Extension to Exhibition of Stage 1 Concept Proposal for the redevelopment of Harbourside Shopping Centre, Darling Harbour West, Sydney (SSD 7874)

Reference is made to your letter received on 16 December 2016 requesting comment and recommended consent conditions from the Heritage Council of NSW for the above proposal.

Rajeev Maini
Acting Manager Conservation
Heritage Division
Office of Environment & Heritage
As Delegate of the Heritage Council of NSW
14 February 2016

1 EXCAVATION PLAN
3000-00 1: 250

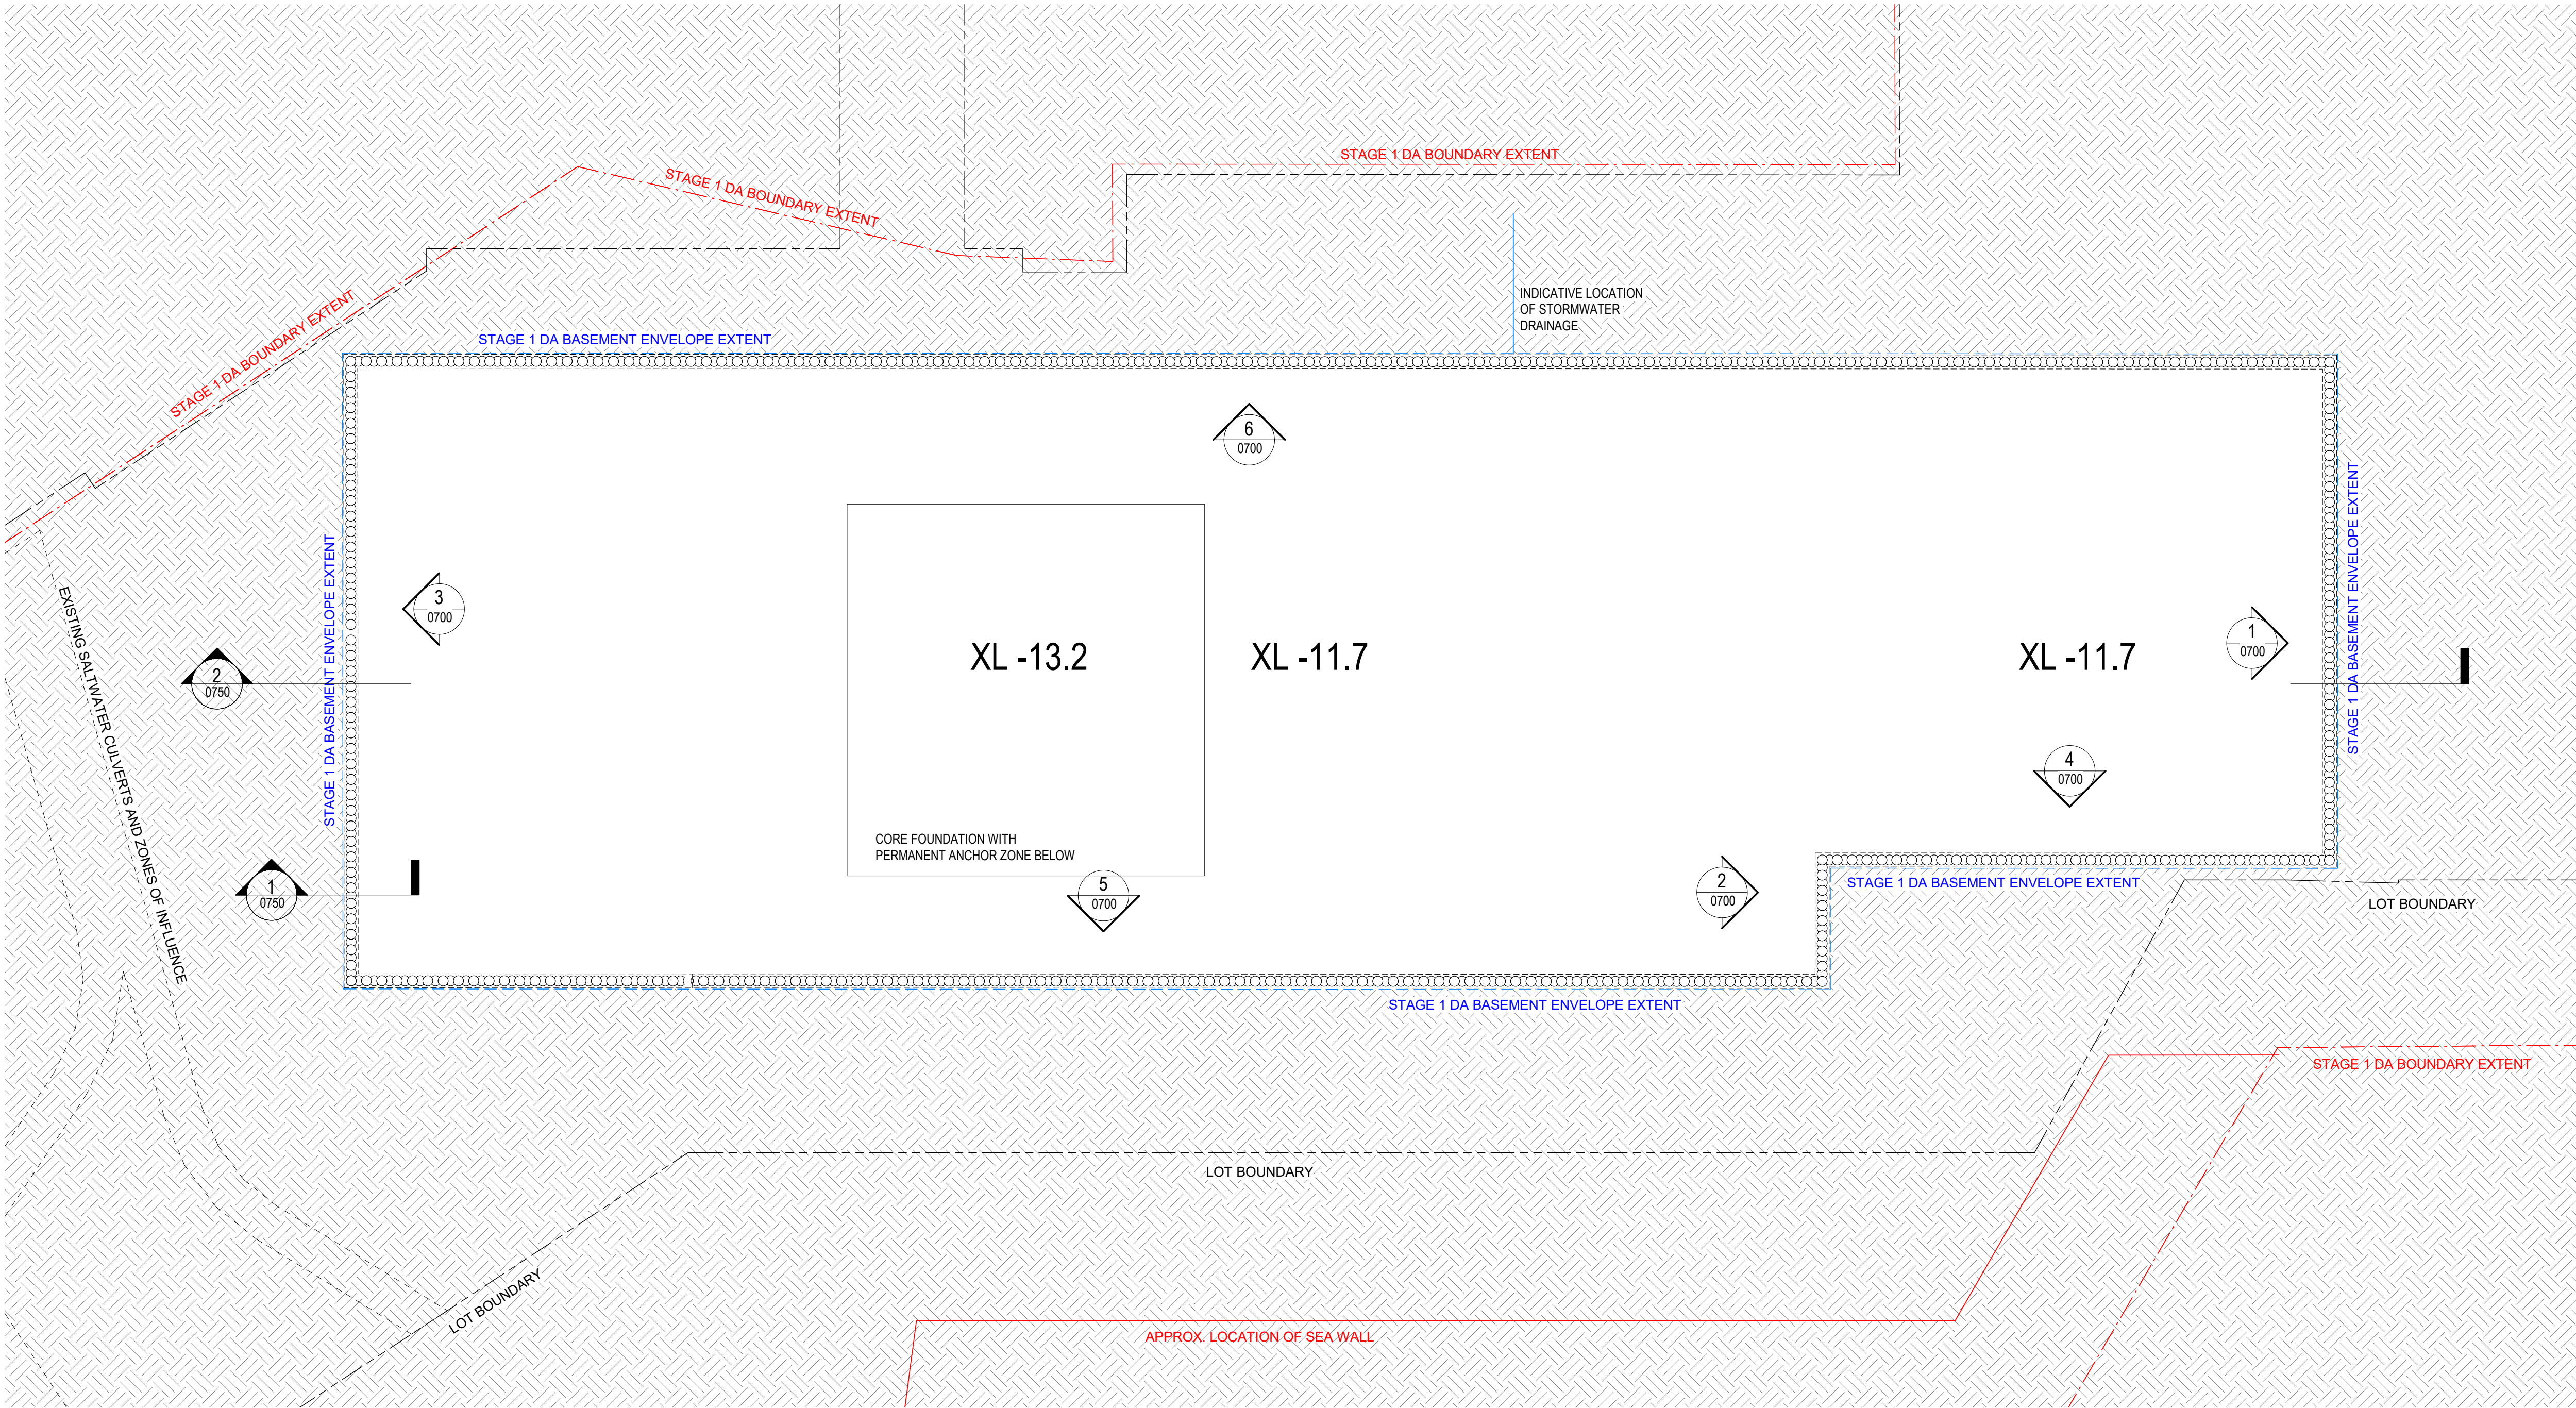
It is noted that the two proposed levels of basement subsurface car parking require excavation to 3.6m below existing ground surface is likely to entirely remove the surviving historical archaeological resource within the basement footprint. This is not considered best-practice given some may be of State significance.

3. The Applicant must retain all state significant archaeological items *in situ* and minimise all impacts from the project to these state significant archaeological items.
